SSD 9227: RESPONSE TO SUBMISSIONS, PROPOSED AMITY COLLEGE SCHOOL CAMPUS AT No.85 BYRON ROAD AND No.63 INGLEBURN ROAD, LOTS 1 & 2 DP 525996, LEPPINGTON, NSW

Proposed Amity College school campus, Leppington NSW: SSD 9227
Outline Planning Consultants Pty Ltd
Town Planners & Project Managers

NOTE: LINE 1A607

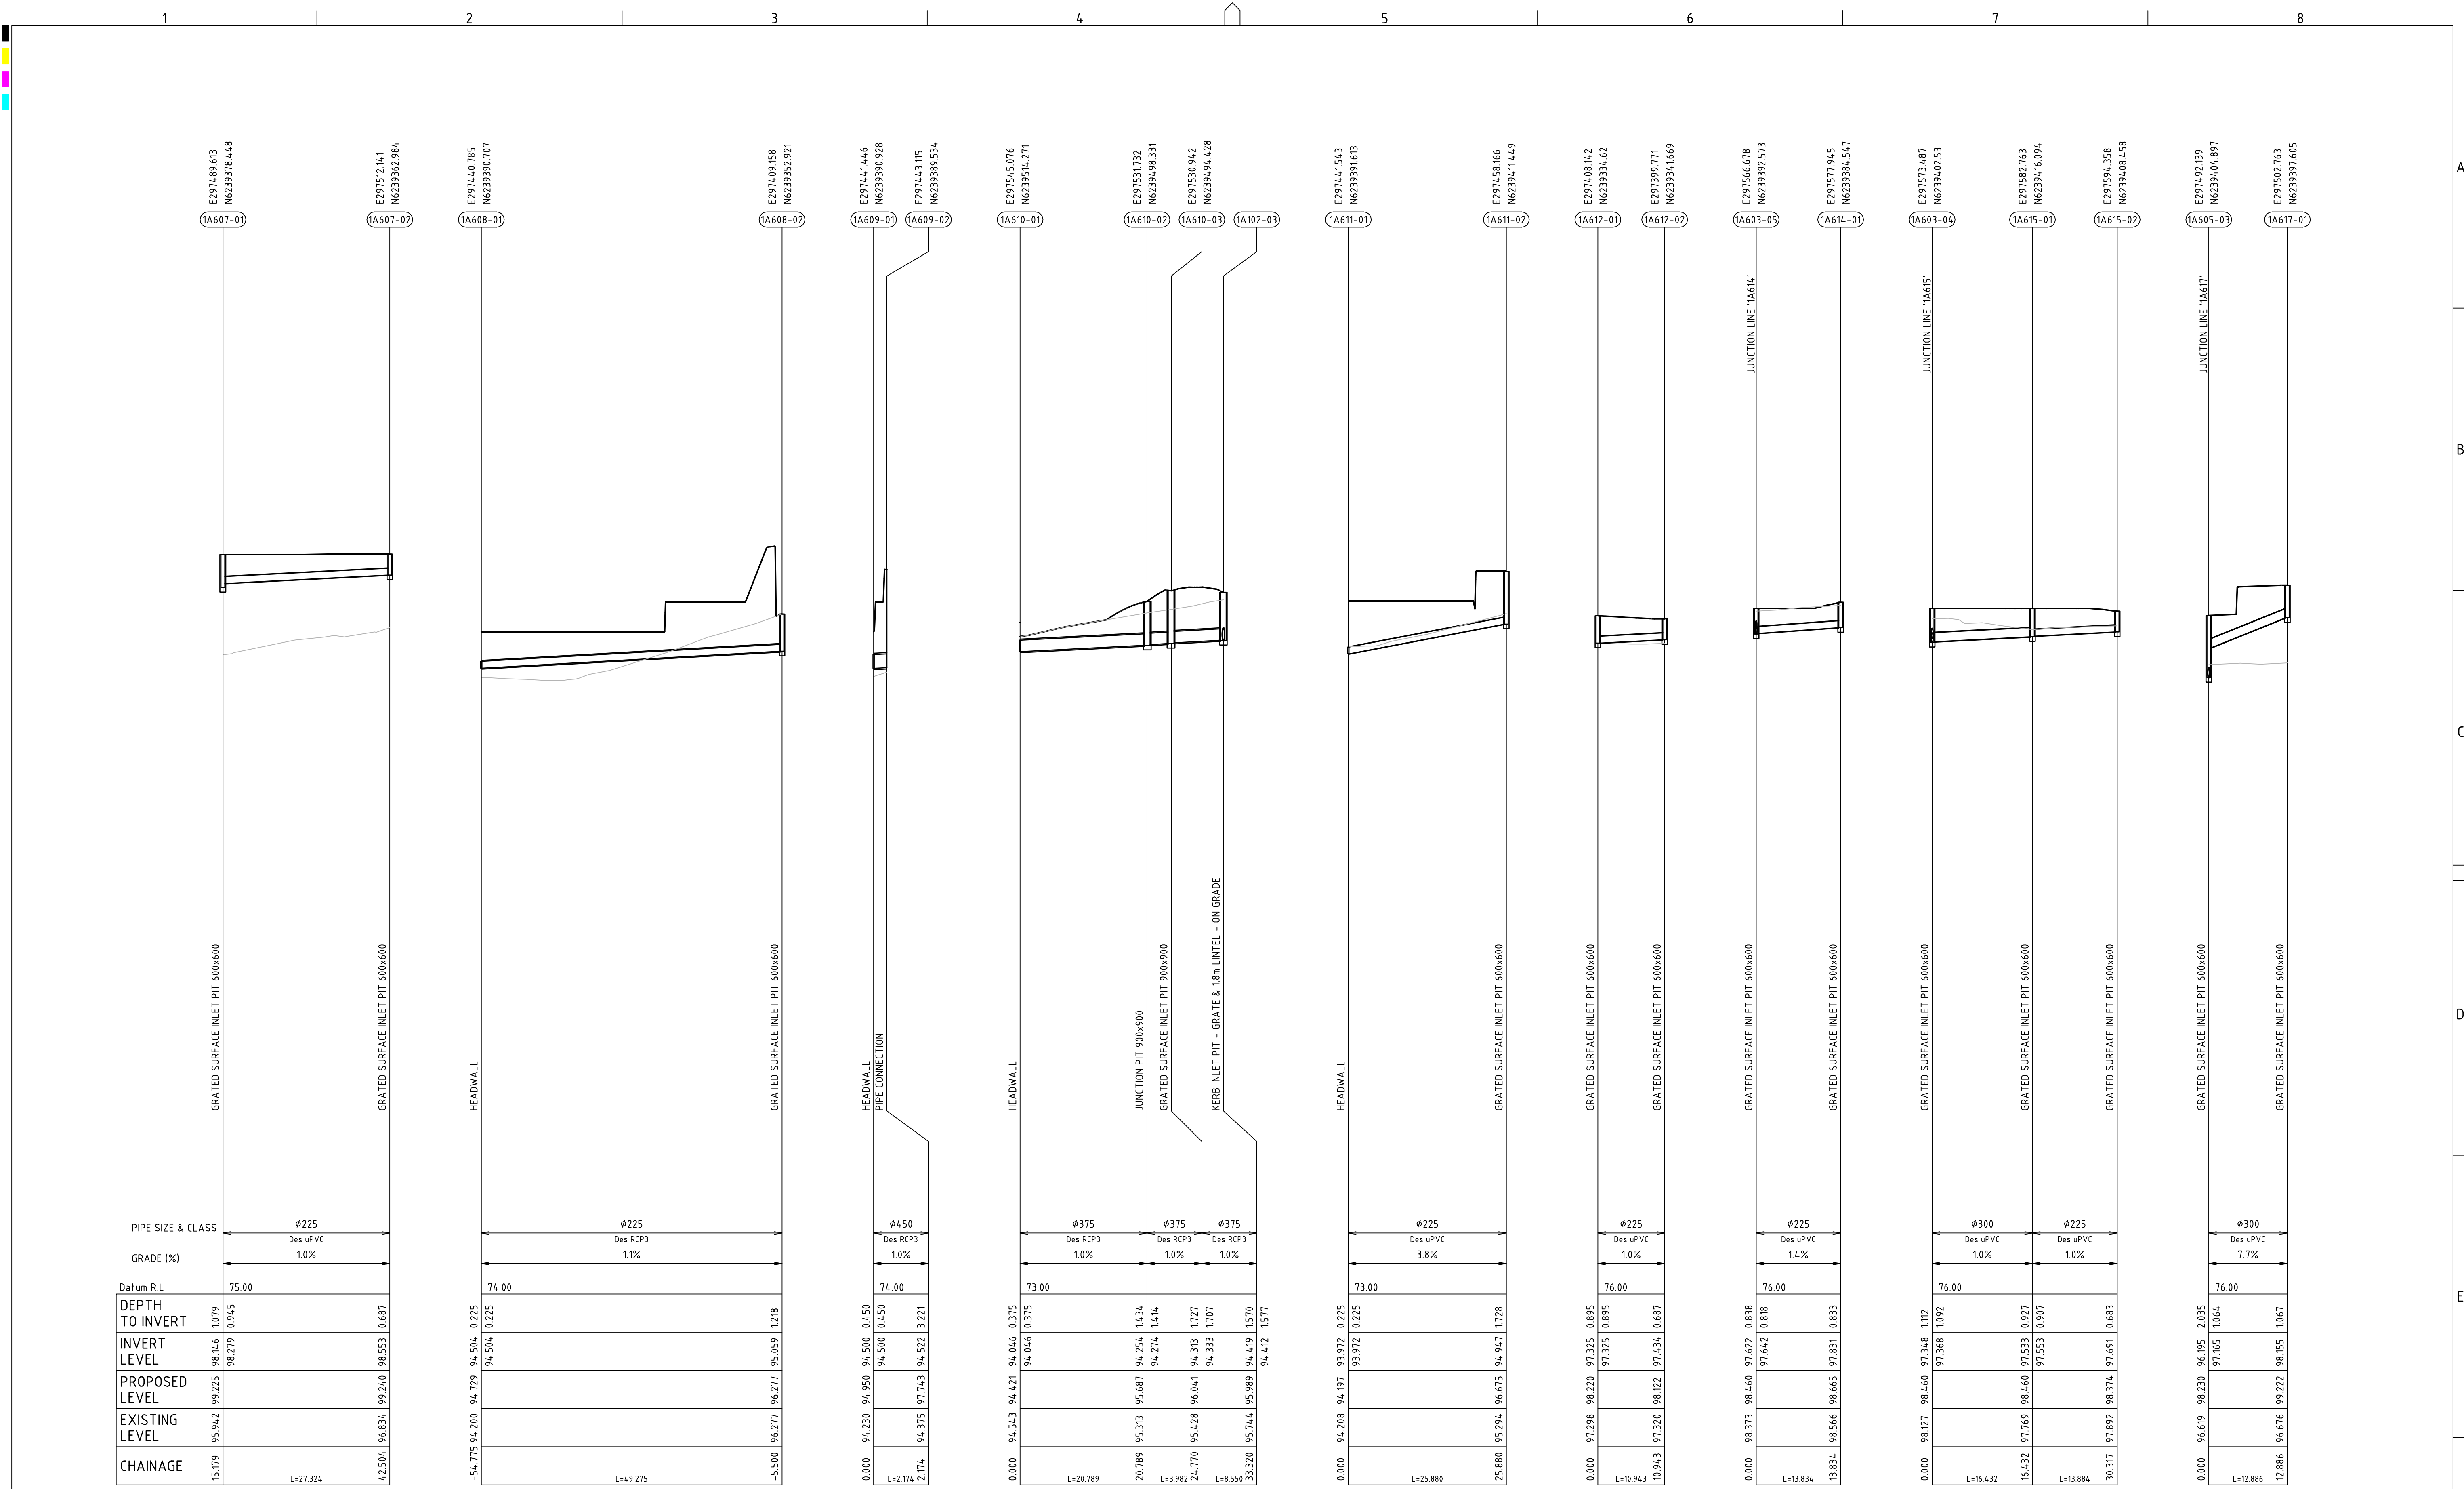
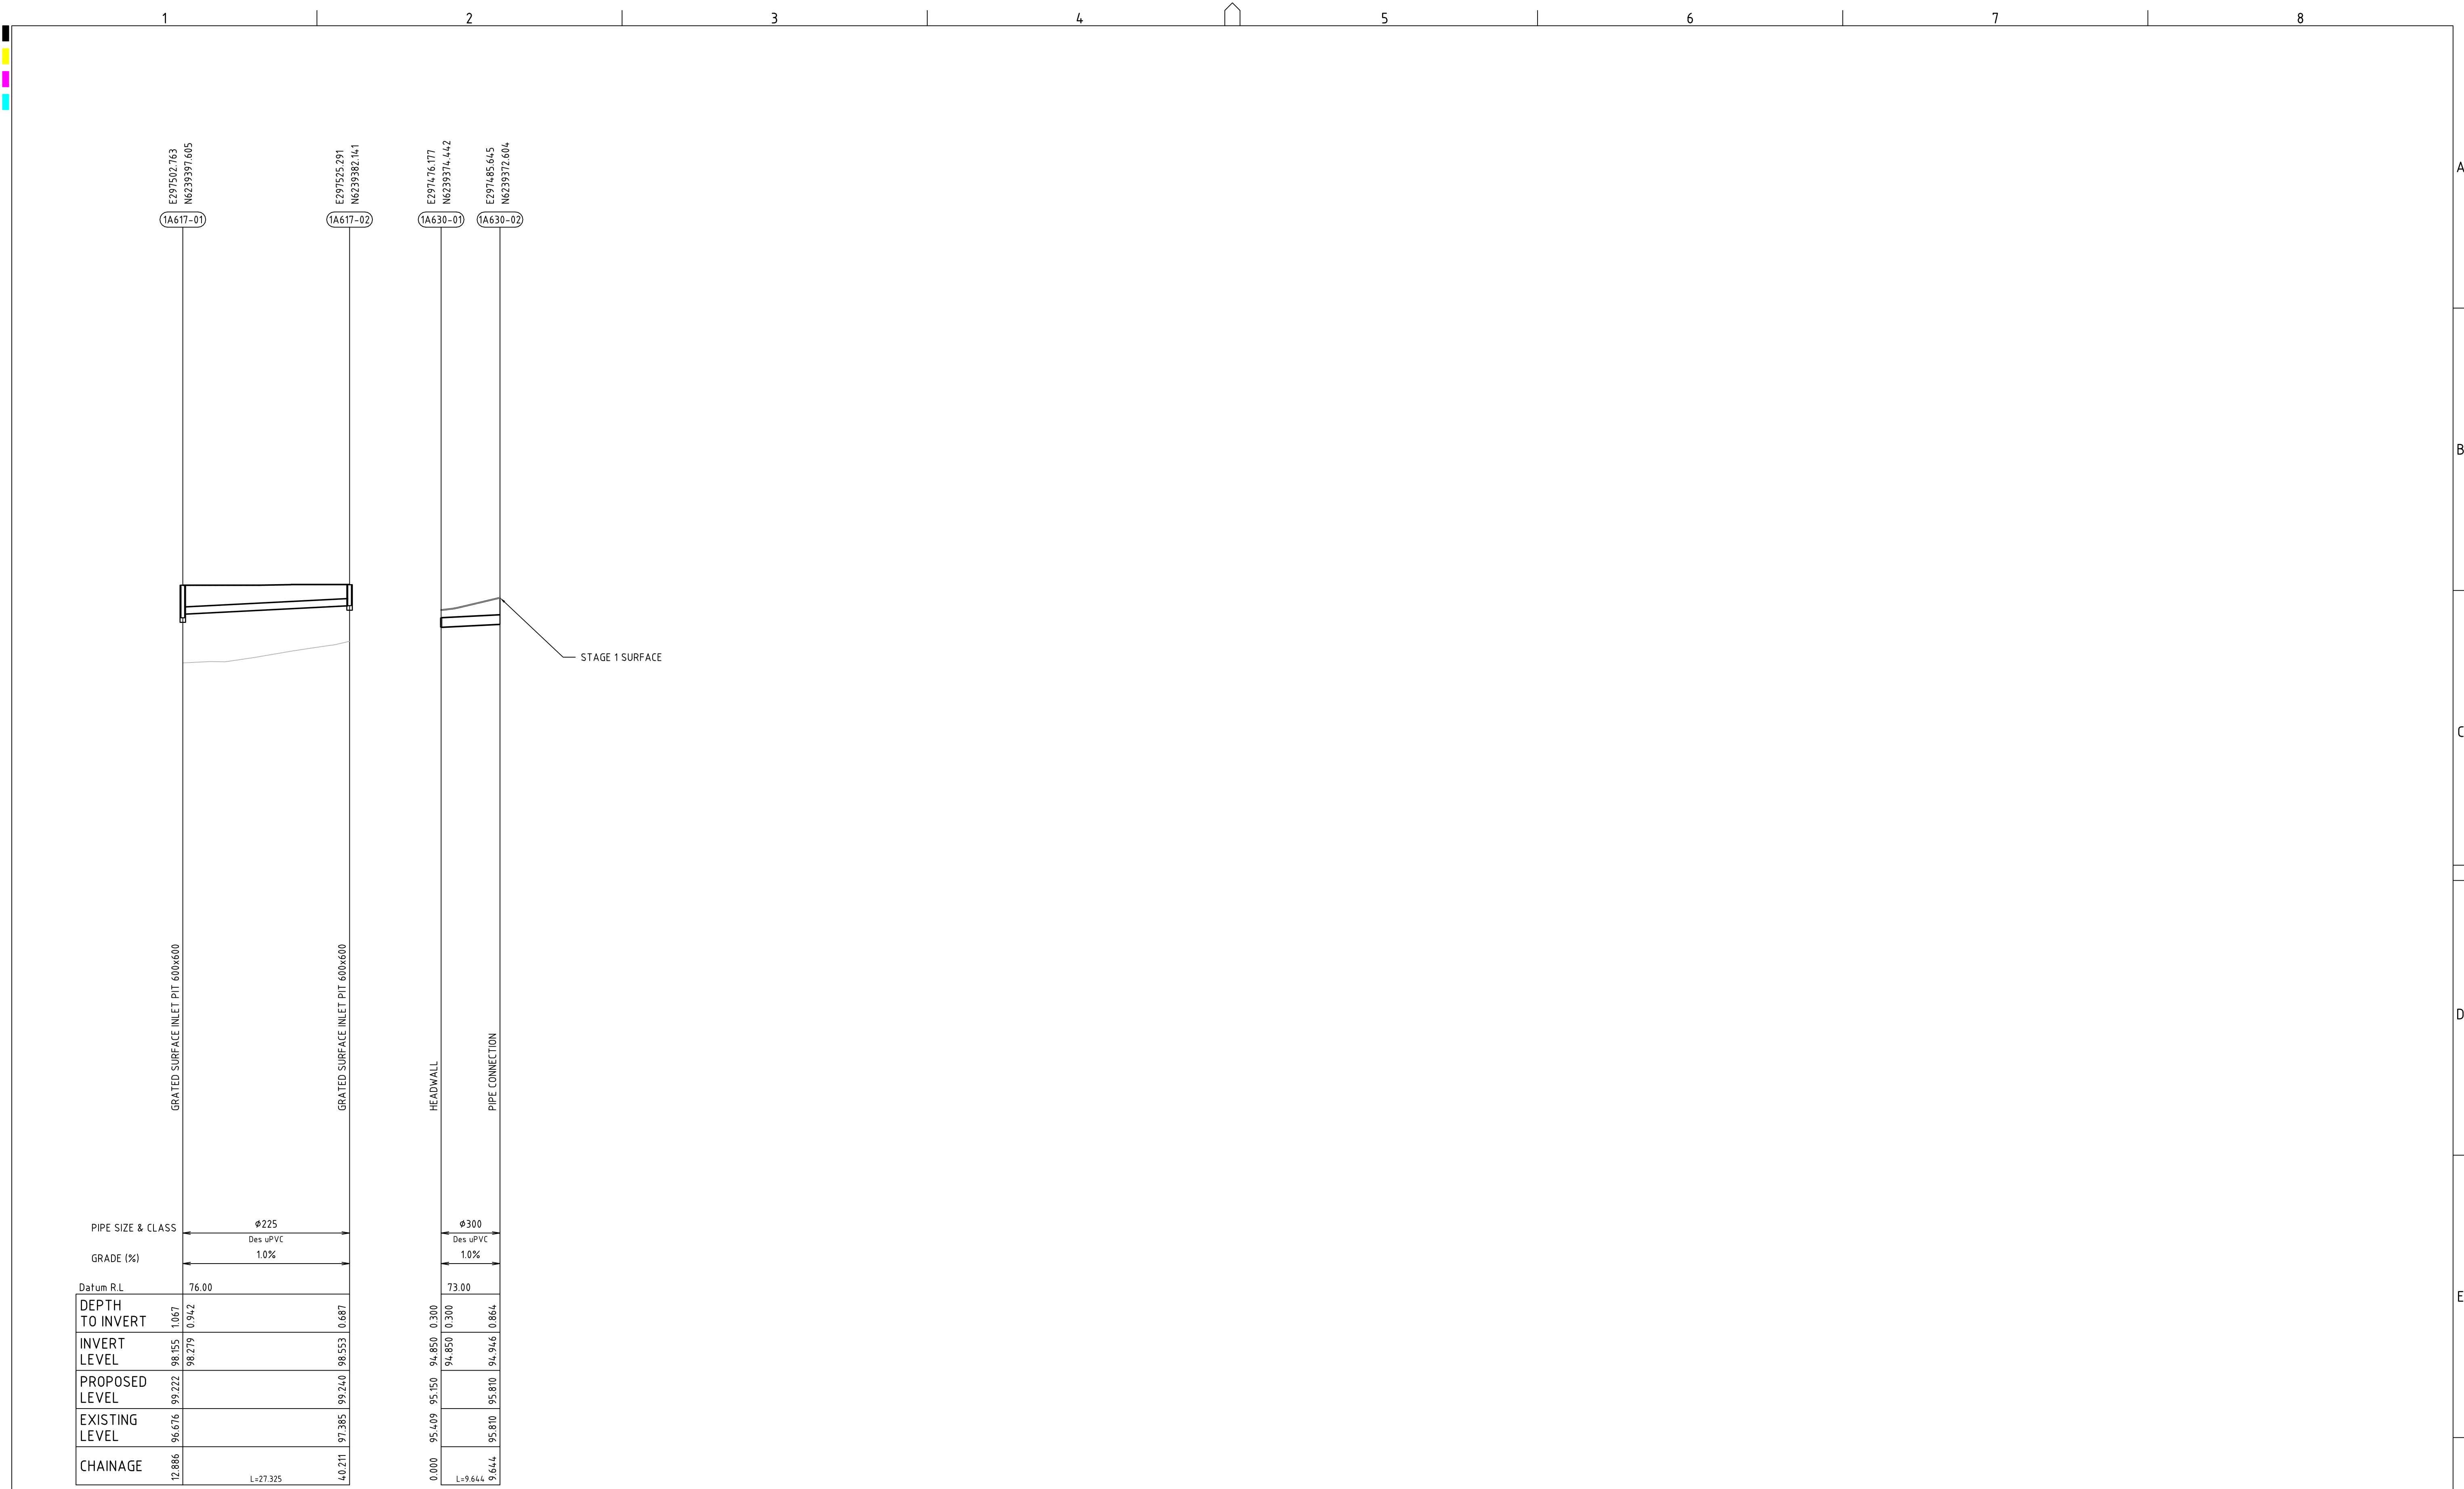
“11. In accordance with the Leppington precinct’s indicative layout plan and water cycle management strategy, the stormwater flows from 63 Ingleburn are to drain to the zoned drainage reserve near 75 Ingleburn Road. Due to these requirements, the following needs to be considered, modelled and incorporated into the drainage design:

- overland flows should not be conveyed through 69 Ingleburn Road as this site is zoned for public open space. A drainage swale is not appropriate through this space,
- the 1% annual exceedance probability (AEP) level flows, from the post development external (in accordance with the indicative layout plan and water cycle management strategy) and internal catchment, are to discharge into the drainage reserve and eventually online regional drainage basin B9, and
- the development and internal roads need to be at or above the post development flood planning level (not the existing flood planning level).”

Not agreed, however, the design of the stormwater drainage system has been modified in order that some of the stormwater flows are directed back into the adjoining Pluto Avenue (road 1) stormwater drainage system, details of which are provided below. In providing the above, the proponent is achieving, in part, Council’s wishes.

- ▶ As requested by Camden Council, and based on the stormwater drainage model and stormwater engineering design used by Crownland’s consulting engineers Mott MacDonald, Martens & Associates have devised a stormwater system that **diverts stormwater from more than 3,000 square metres of the flows from the Amity College school site into the Crownland Pluto Avenue road drainage system**. Additional flows cannot be diverted to this system based on the carrying capacity of the existing stormwater system in the road. Refer **Appendix C** for details.

- ▶ All other stormwater flows within this catchment will be diverted back to the natural low-point on the school site, and thence to the natural drain line that runs to the west of the school (ie. Over the land zoned open space). Stated another way, the residue of stormwater flows will continue to naturally drain into the land below at No. 69 Ingleburn Road.
